Historic England

**NEW MILLS, BROUGHAM ROAD, MARSDEN, HUDDERSFIELD, HD7 6AZ
Application No. 2026/62/90232/W**

Thank you for your letter of 21 April 2026 regarding the above application for planning permission. On the basis of the information available to date, we offer the following advice to assist your authority in determining the application.

**BUILDING B PROPOSED FLOOR PLANS**

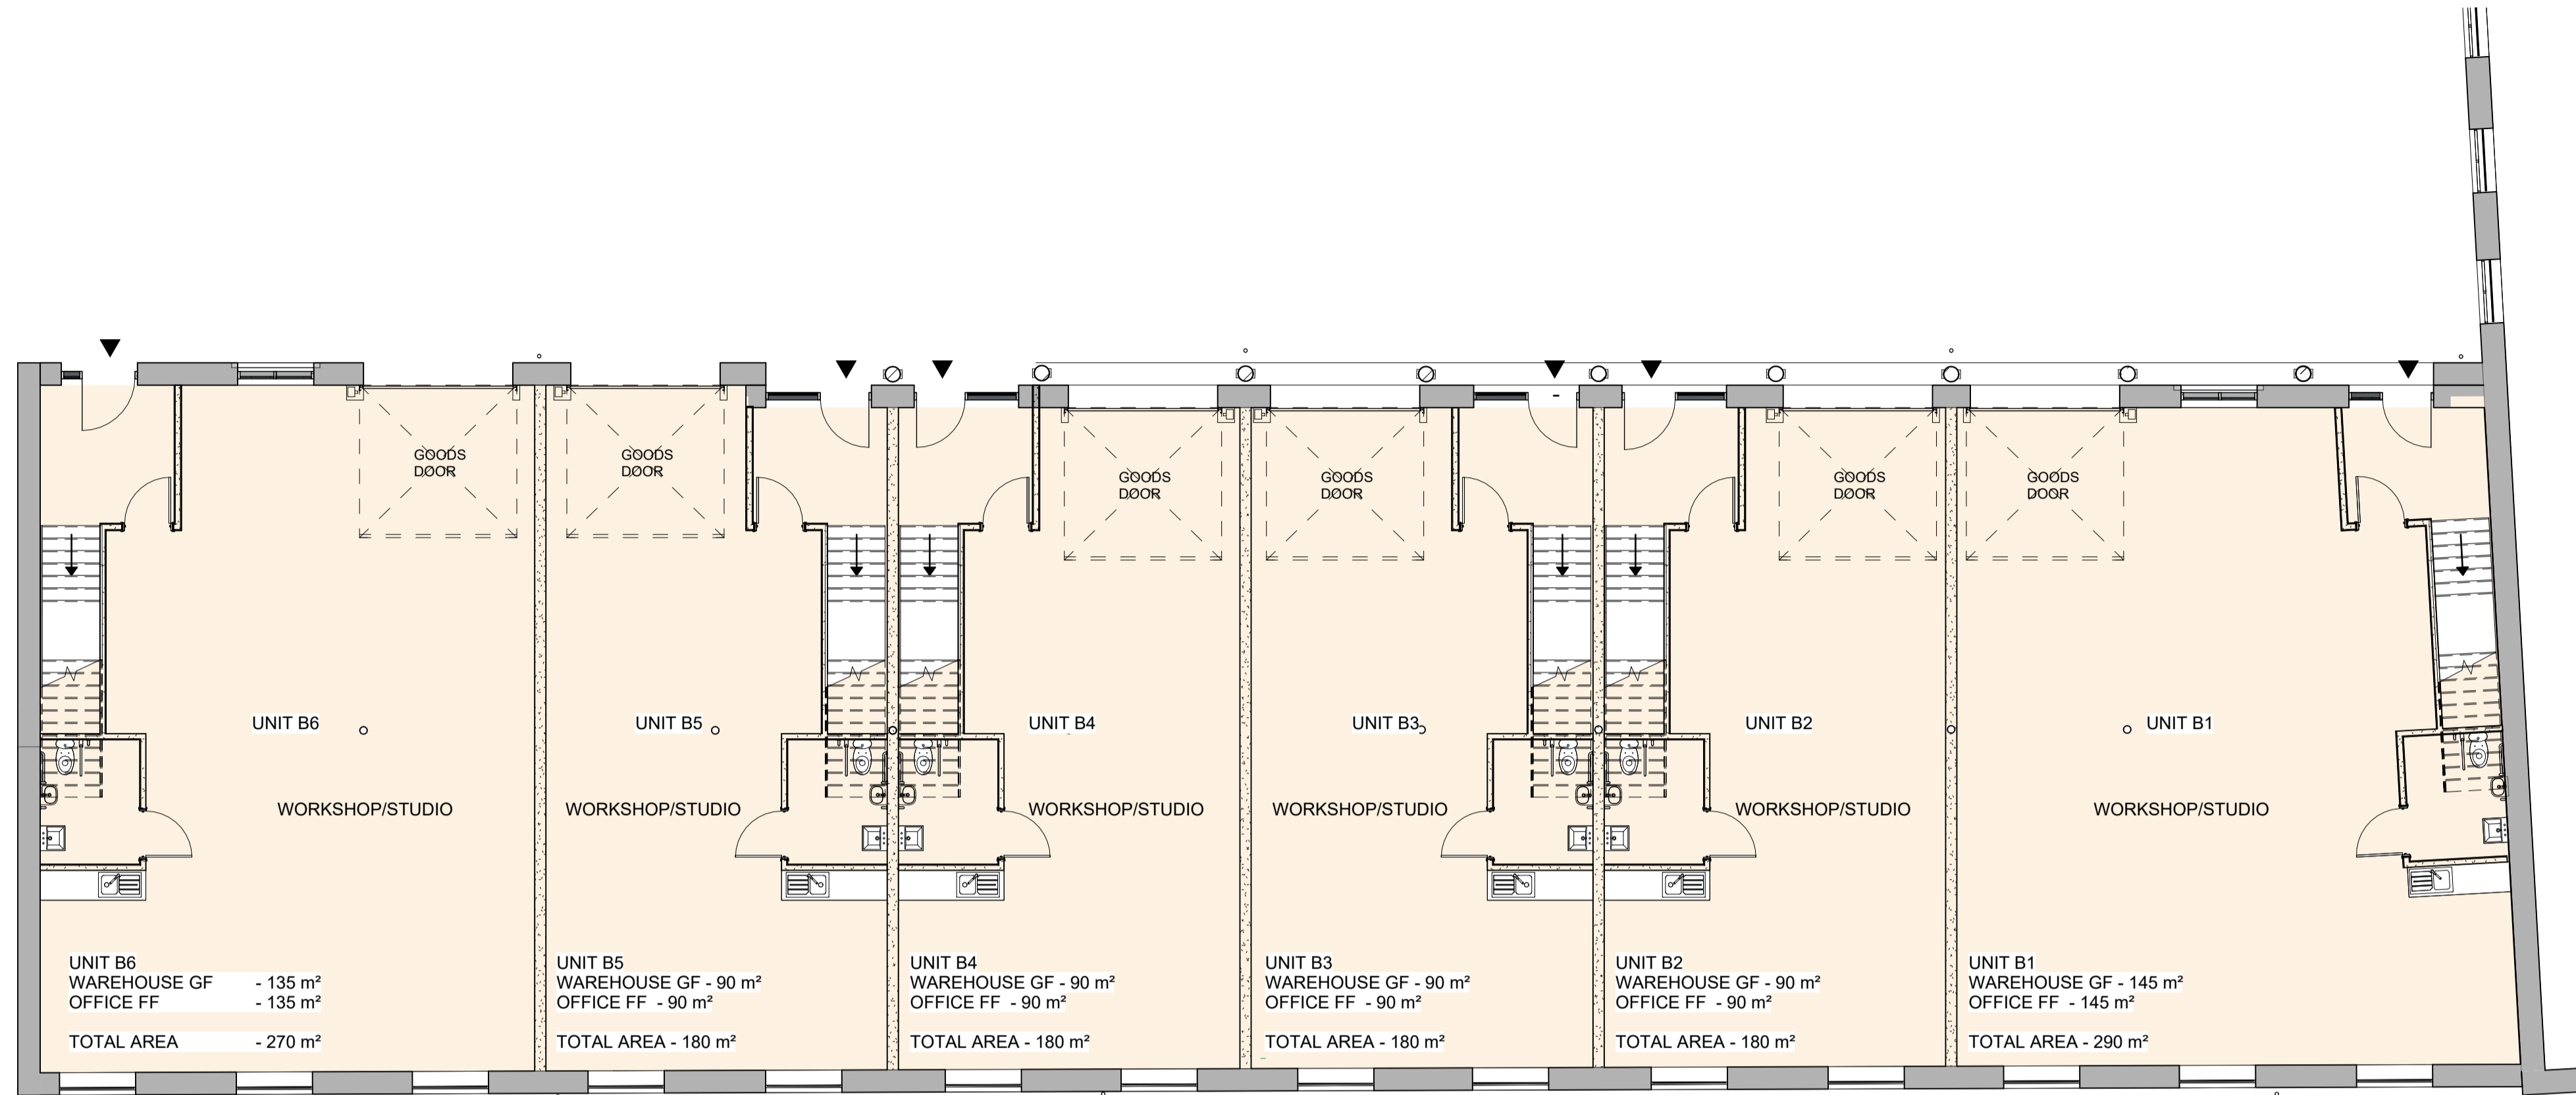
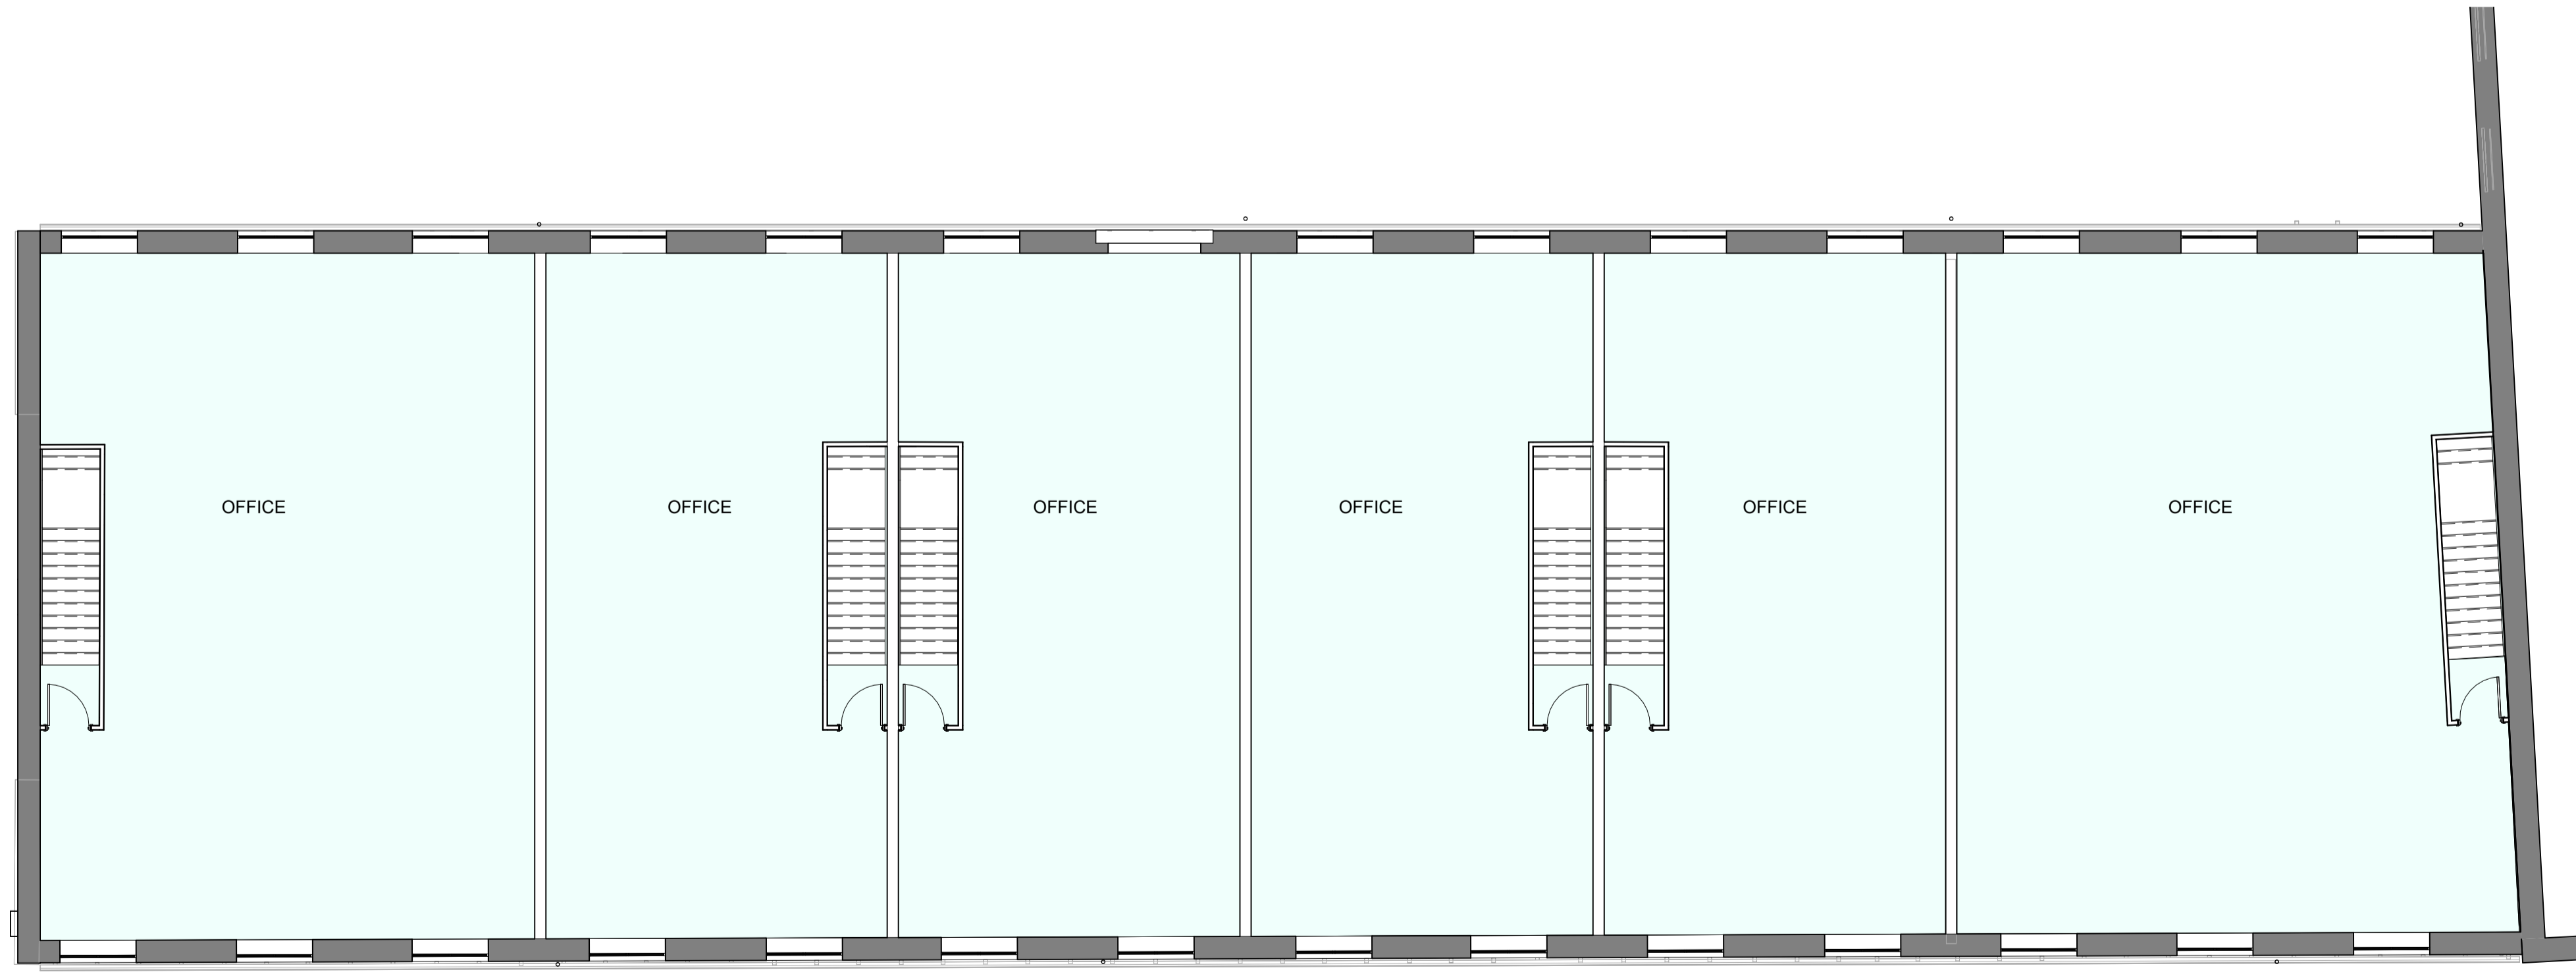
The new build element seeks to utilise contemporary materials but would mirror the form of the double pitched mill buildings. This has the potential to cause a very small amount of harm to the significance of the conservation area through the use of the stark, black cladding.
